Response to Submissions Report

Alterations and Additions to Parramatta West Public School
Auburn & Young Streets, Parramatta

11 October 2019

Figure 12: Axonometric sketch

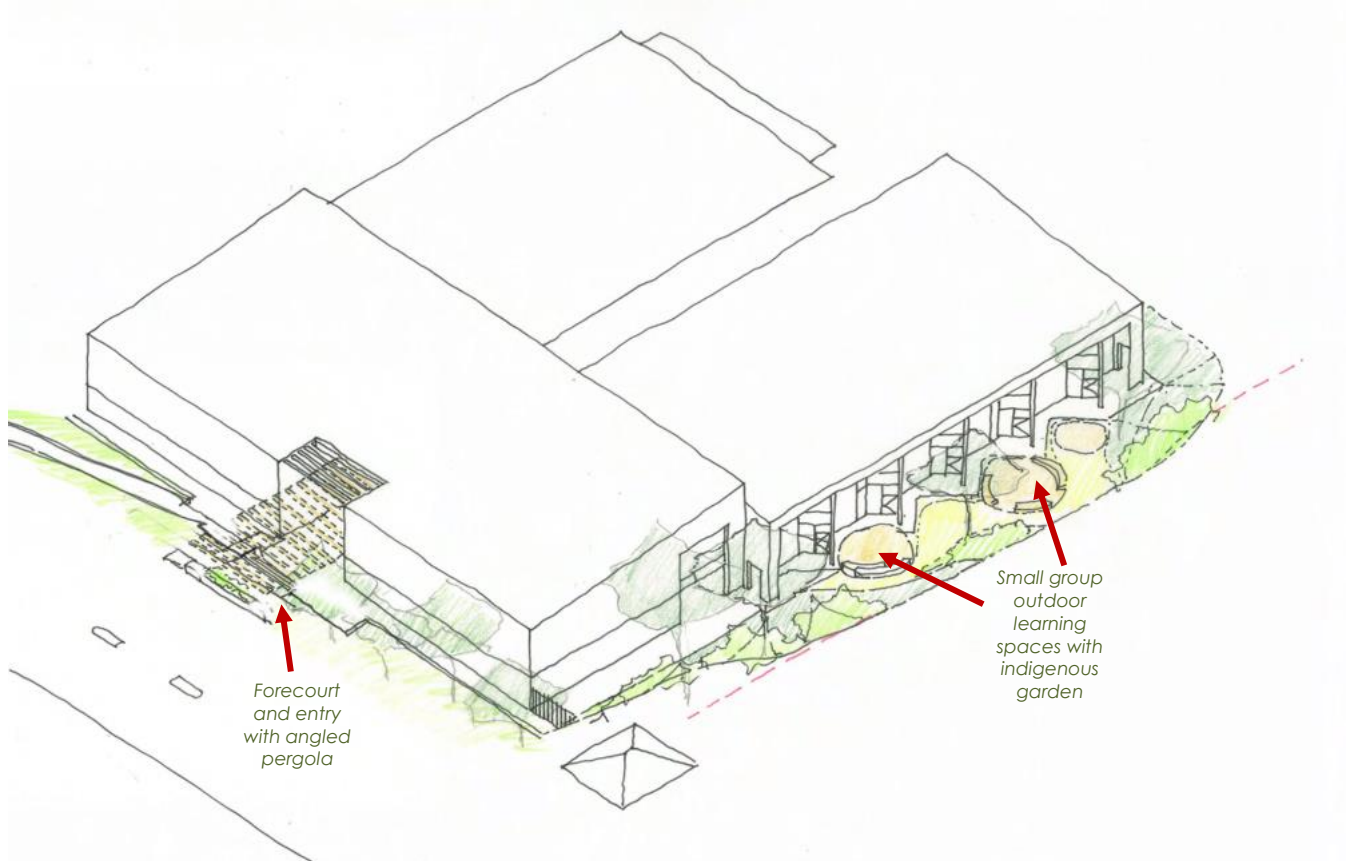
1p	The Landscape Masterplan at Appendix G of the EIS shows the location of 'informal yarning circles for outdoor learning' located along the eastern façade of the new school hall. These informal outdoor learning areas should be relocated to the western side to minimise potential noise impacts on the adjoining residences along Franklin Street.	The yarning circles were specifically located in this area and were proposed only to be used in a limited manner by teachers and small groups of students in a completely supervised manner. There is no direct access from the classrooms and the number of circles has been reduced from three (3) to two (2) to limit the use and number of children. These areas are not proposed to be part of the open play space so the noise will be limited and less than existing. This is an improvement on the current situation where the playground directly adjoins the neighbours' boundaries. Amended Landscape Plans have been prepared relating to the yarning circles and are included in Appendix J.
